From: Miriam Kelly <mirskelly@gmail.com>
Sent: Monday 22 April 2024 17:56
To: Appeals2
Subject: Observation on Ref: 319218. Hudson's Brothers Ltd.
Attachments: Hudson Brothers observation submission Ref 319218 final.docx

Submission of Planning Objection:

Ref: 319218.

For: App Hudson's Brothers Ltd.

| TITLE | EXISTING SITE CONDITIONS - NORTHERN AREA | | |

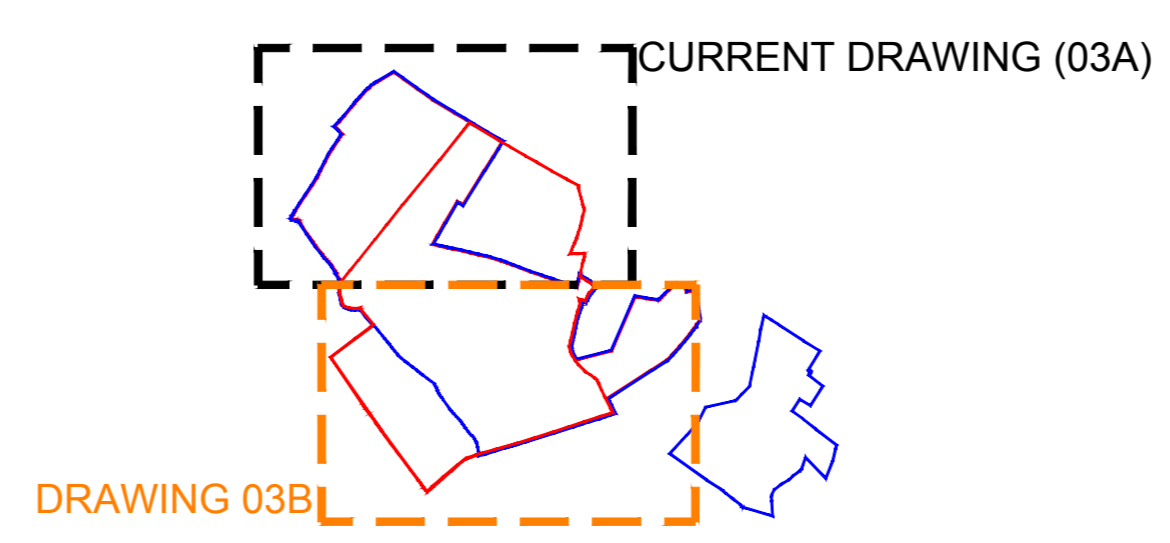
- There are several houses and septic tanks not showing on the map both existing homes and ones that have been newly granted planning permission.
- With regards to the buffer zone: Requirement of a buffer zone around natural ecosystems and to protect them there is not enough information facts or reports to determine the buffer zone and what impact the quarry and its workings will have on the local area.

- It does not appear to show the full scale of the gas pipe and exactly where it is located throughout the whole proposed site this an extremely crucial element and there can be no room for error and little proof of engagement with the appropriate state body in relation to this or indebt investigations or reports.
